WEST SUSSEX COUNTY COUNCIL CONSULTATION

TO:	Arun District Council FAO:
FROM:	WSCC – Highways Authority
DATE:	1 September 2026
LOCATION:	Ferring Country Centre And Riding Stables Rife Way Ferring BN12 5JZ
SUBJECT:	FG/76/26/PL Change the use of a field (currently used as an occasional overflow carpark) to a dedicated overflow carpark. This application affects a Public Right of Way.
DATE OF SITE VISIT:	n/a
RECOMMENDATION:	No objection/More information

FCC - Overflow Car Park

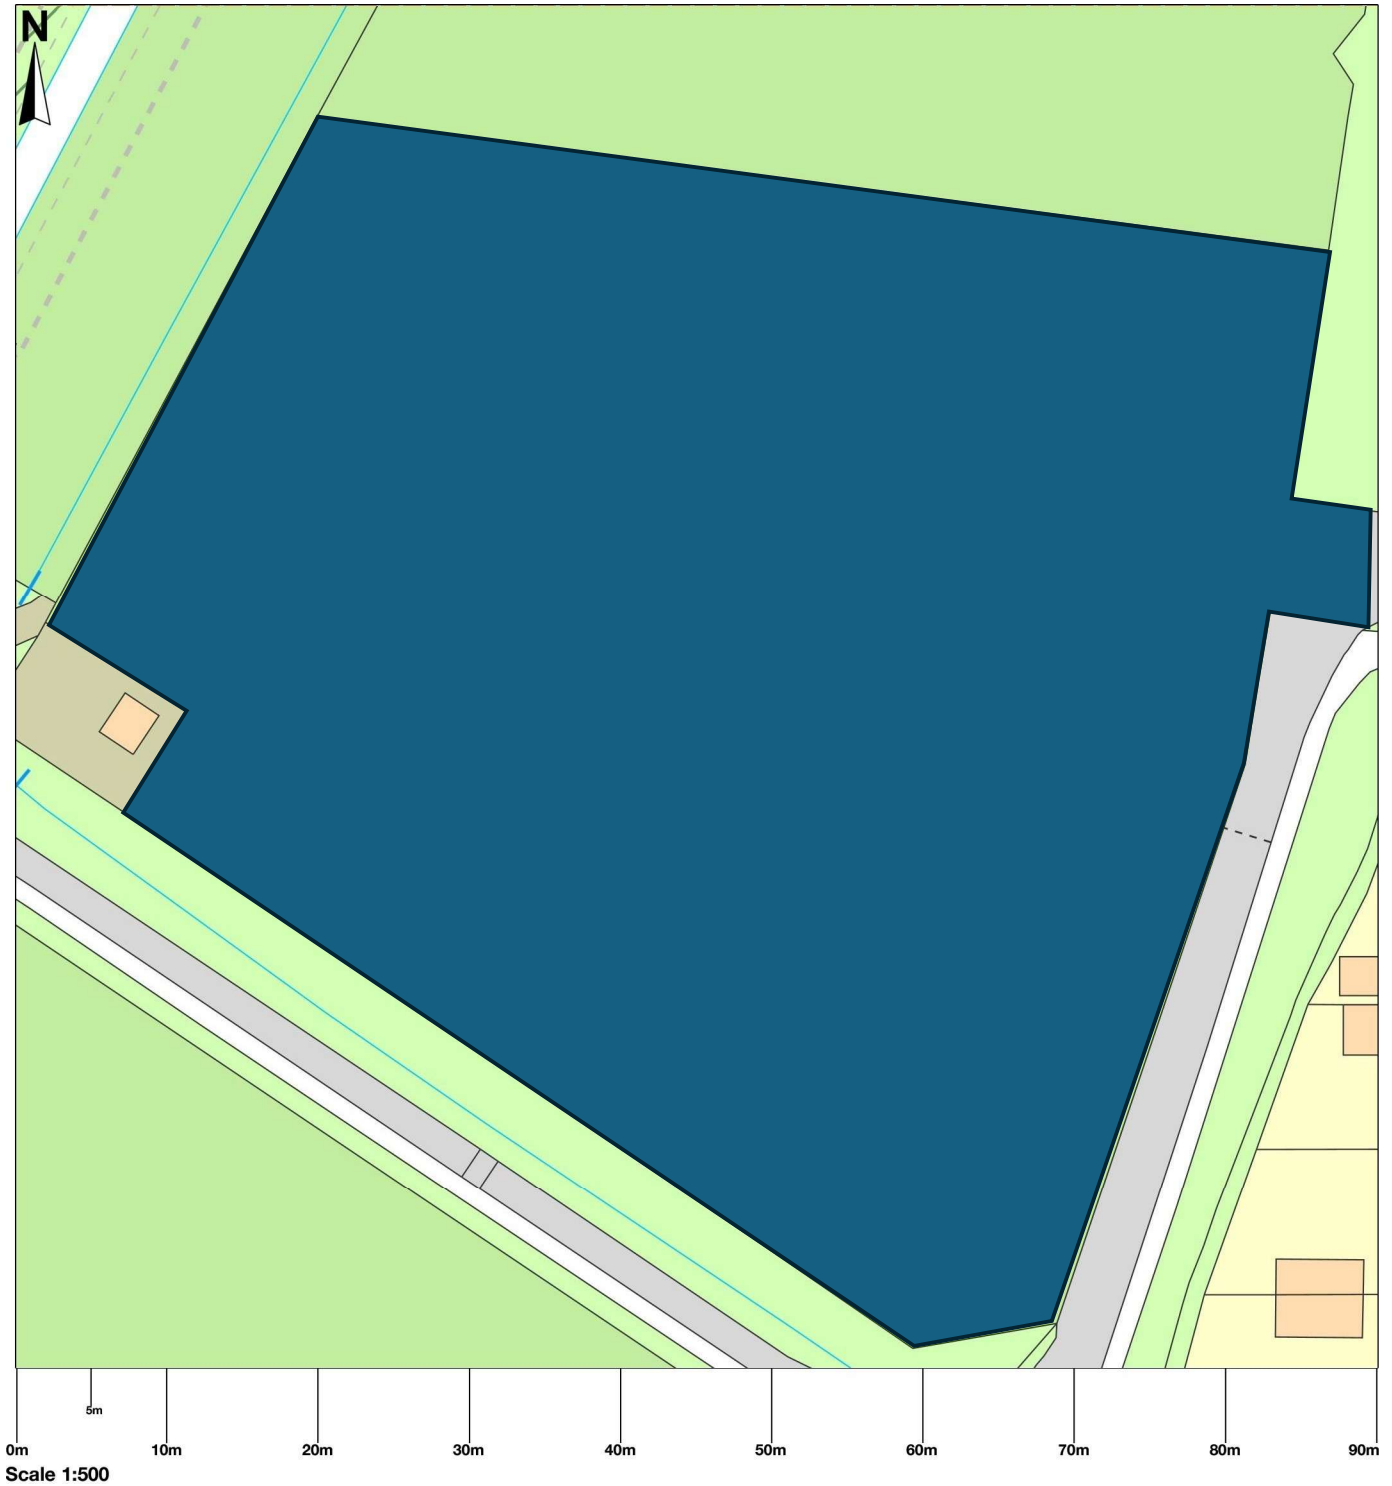
The application is for a dedicated overflow car park with 160 spaces, no changes proposed to surfacing or access.

The applicants have described the proposal as self-limiting and will not be used in the winter or in wet weather. However this may be unavoidable on occasion therefore consideration will need to be given to how the facility will be managed in poor weather to mitigate debris on the public highway.

No information has been provided on typical numbers or on how the site will be accessed. It is assumed to be via Rife Way.

Consideration will also need to be given to the Public Right of Way (PROW). Consultation with out PROW team is required.

No objection given the site is currently being used in this way and the application appears to be a formalisation. However, information is limited and confirmation of the following is required:

- Wet weather management strategy (in case of adverse weather during an event)
- Details of typical numbers
- Confirmation of the Rife Way Access
- Consideration of the PROW comments.
